**Subject:** A/99/17/OUT - Land South of Water Lane Angmering

**Planning Application No:** A/99/17/OUT

### Highways England Planning Response (HEPR 16-01)

Location: Land South of Water Lane, Angmering.

TITLE: PROPOSED IMPROVEMENT SCHEME TO A280 / A27 / TITNORE LANE ROUNDABOUT	
PROJECT: LAND SOUTH OF WATER LANE, ANGMERING	CLIENT: RYDON HOMES, GLEESON DEVELOPMENTS LTD

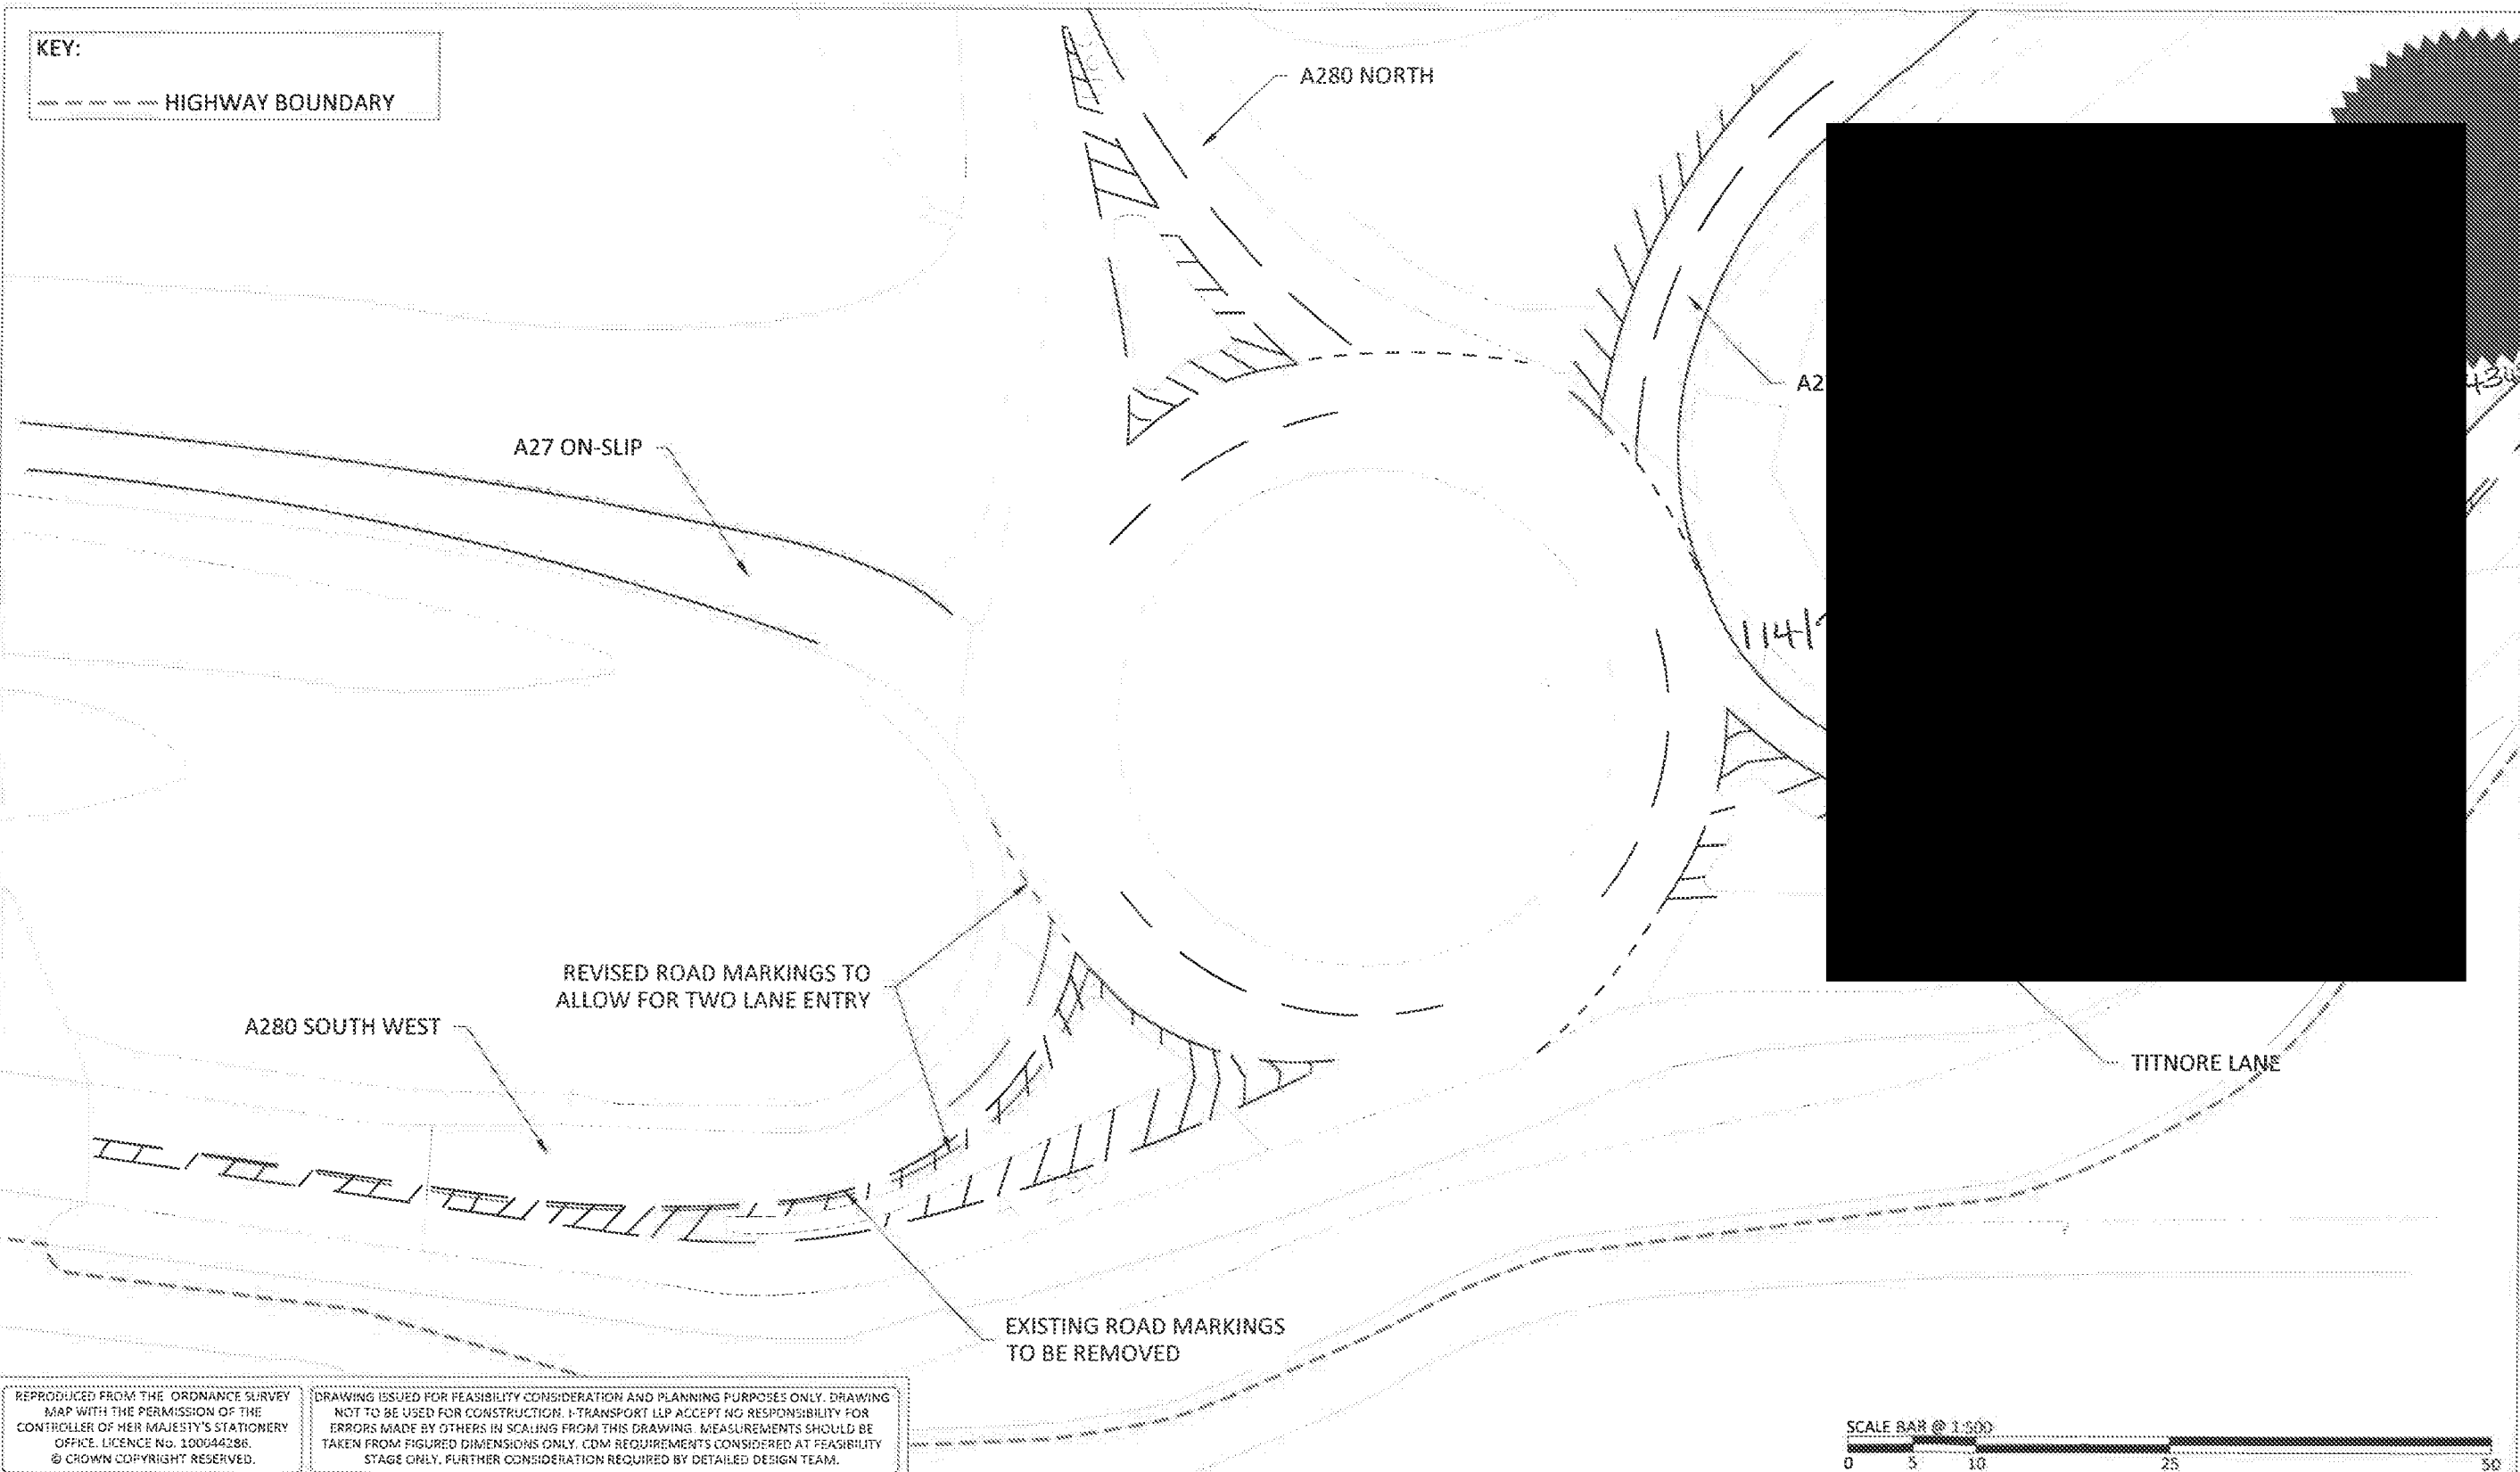
No part of the development hereby permitted shall be commenced until completion of the highway improvement works as shown on i-Transport's drawing number ITB9105-GA-023 A280 / A27 / Titnore Lane Junction Interim Improvement Scheme shown (or such other scheme of works substantially to the same effect, as may be approved in writing by the local planning authority (who shall consult with Highways England)), including any necessary transfer of lands to enable the construction and maintenance of the scheme, and that scheme is brought into use.

**Reason:** The modifications have been proposed to provide sufficient capacity at the A280 / A27 / Titnore Lane Junction. This is to ensure that the A27 Trunk Road continues to be an effective part of the national system of routes for through traffic in accordance with section 10 of the Highways Act 1980 and to satisfy the reasonable requirements of road safety.
